Schott Solar - PROPOSED TRACT D  
(Mesa del Sol, Innovation Park II)

Jeff,  
I have finished reviewing the DRAFT Schott plans. Comments will be listed per sheet:

Re: Schott Solar Phase 1 Grading and Drainage Plan

Re: Schott Solar Phase 1 Grading and Drainage Plan Comments

JOB NO. 366450	REV. NO.
FILENAME	DWG. NO. GN-CD-103
SCALE 1"=30'

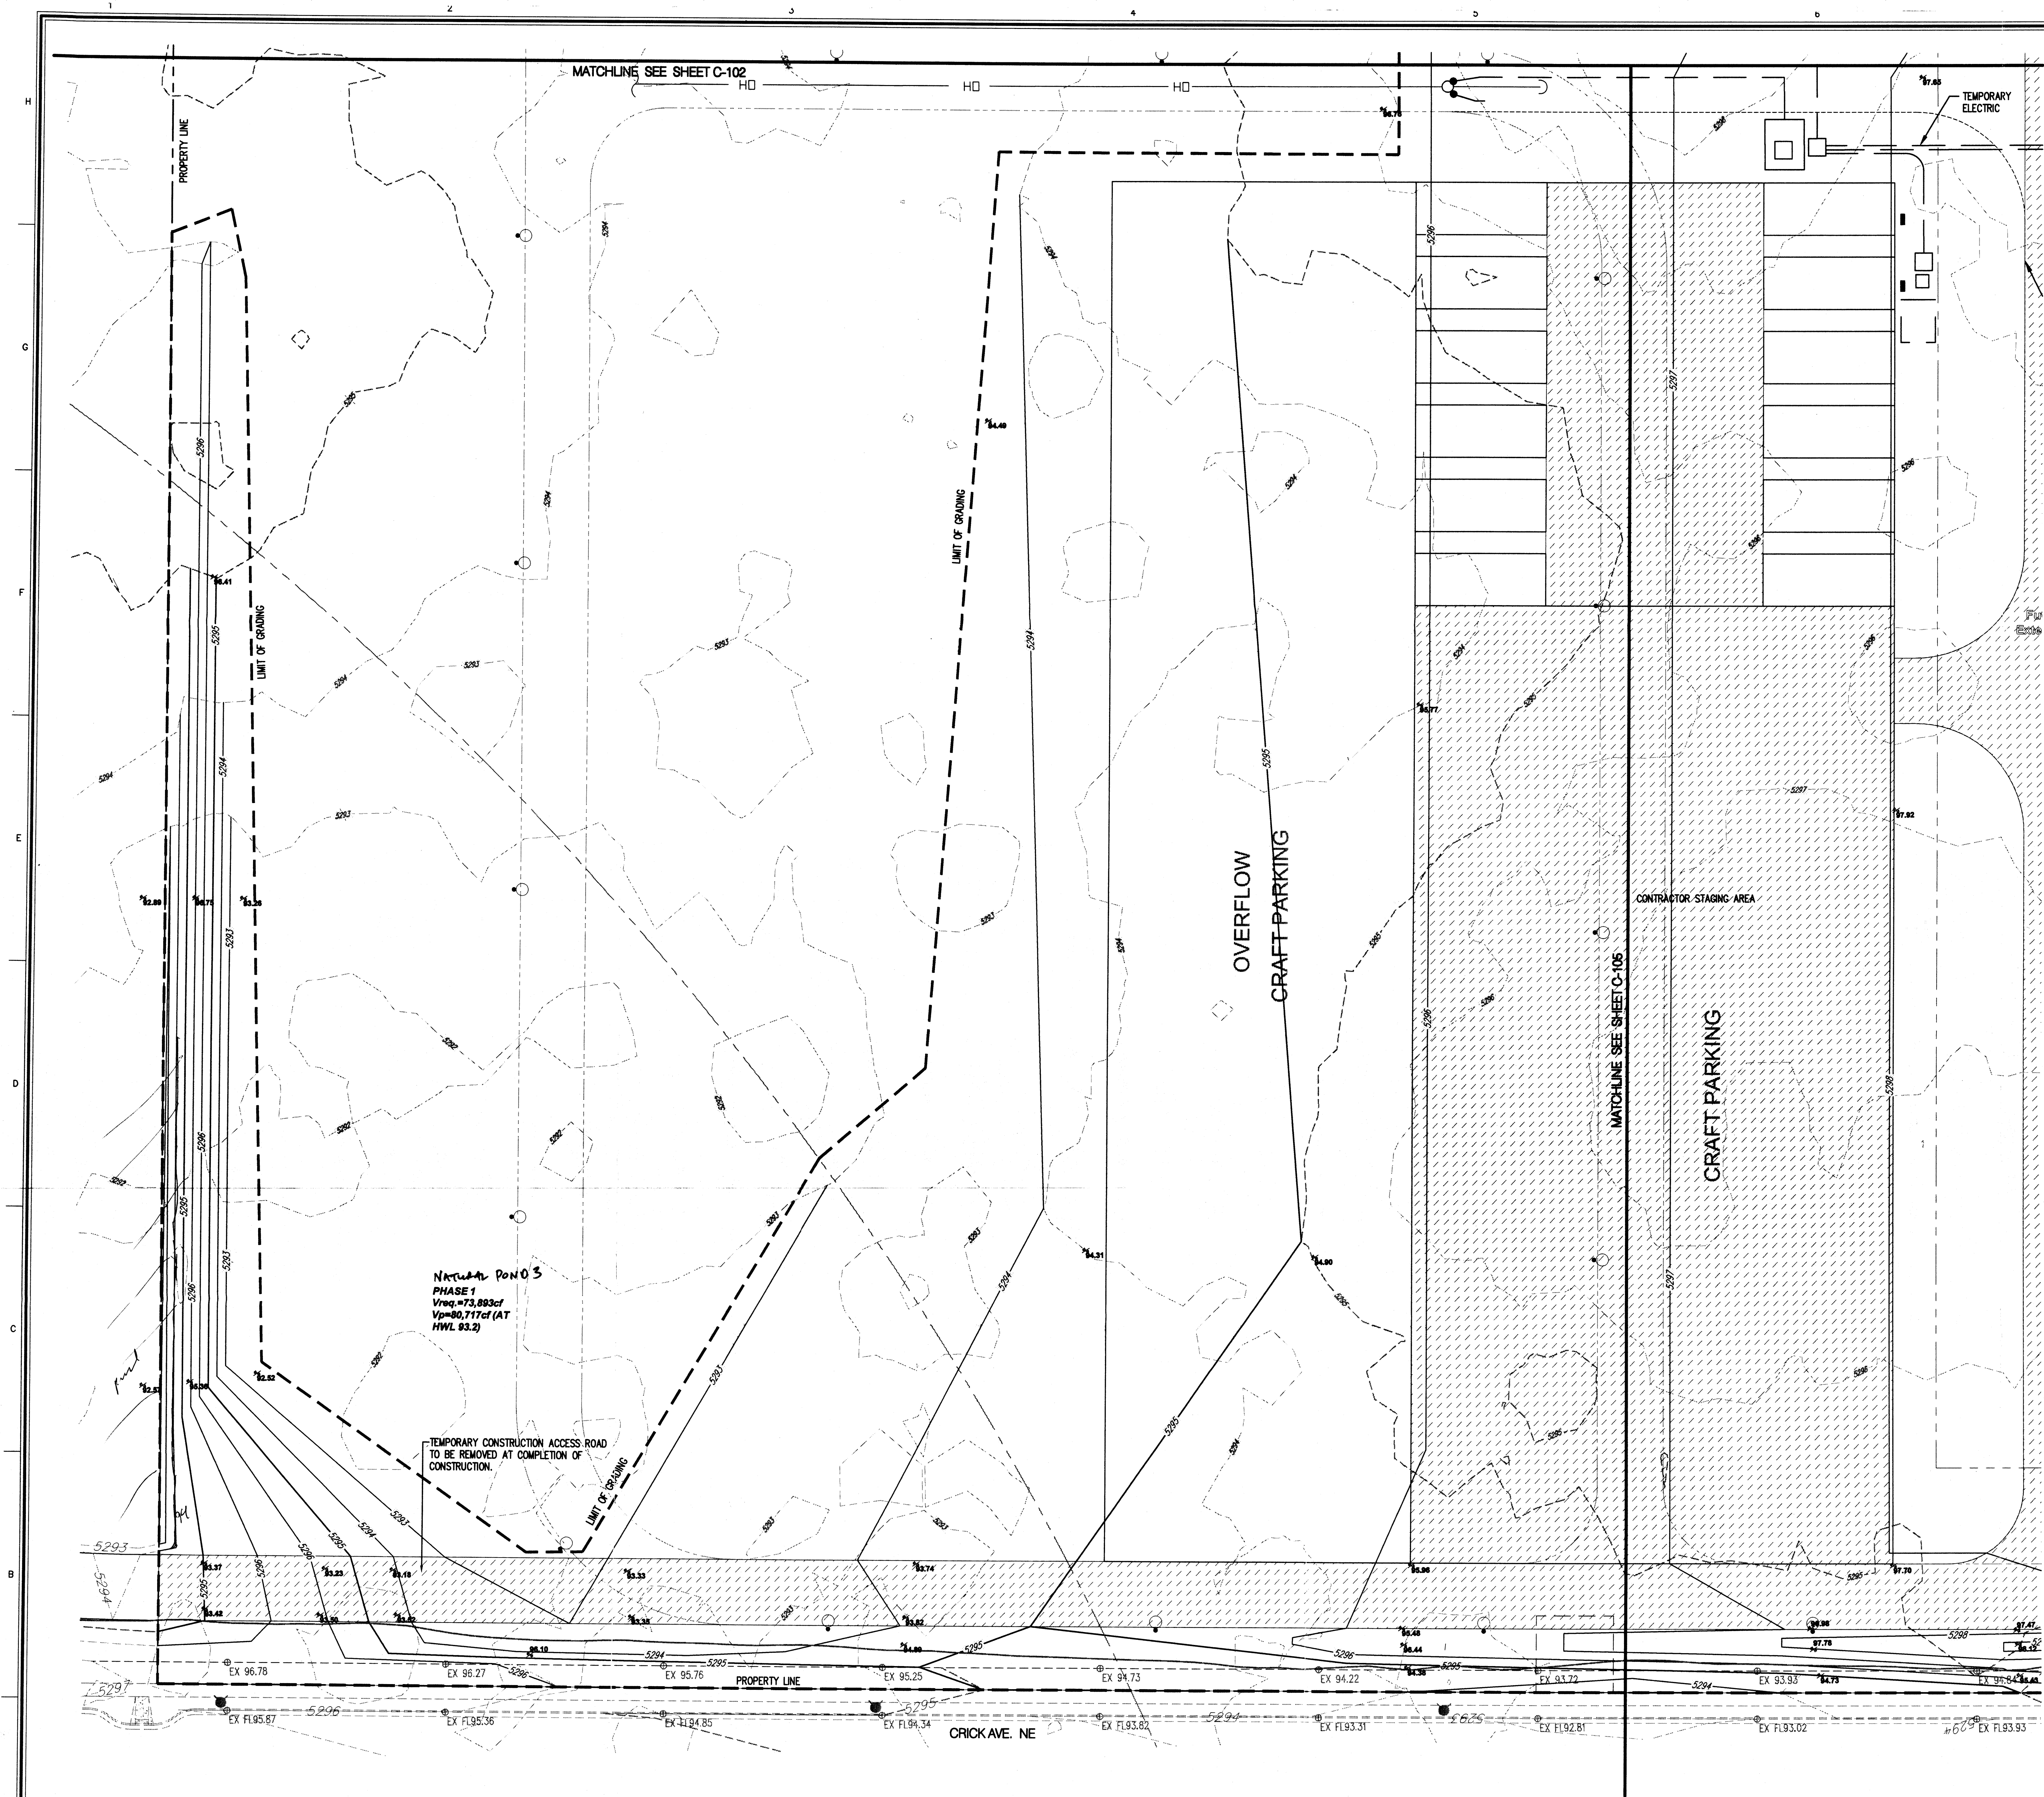
103:  
Part of Basin 7 is in Basin 5 (more of a DMP comment).

A couple of build notes in the northwest area are cut-off. The entire note should fit on one sheet.

One grate elevation is at 95.63 and surrounding grades are 98/99. Seems a little low.

Note 9. The curb cut detail is not on the sheet.

Sheet 103:

- *Part of Basin 7 is in Basin 5 (more of a DMP comment).*  
The boundary of Basin 7 has been adjusted and the calculations updated.
- *A couple of build notes in the northwest area are cut-off. The entire note should fit on one sheet.*  
The notes have been moved.
- *One grate elevation is at 95.63 and surrounding grades are 98/99. Seems a little low.*  
This grate elevation has been changed to 98.33.
- *Note 9. The curb cut detail is not on the sheet.*  
This has been corrected.
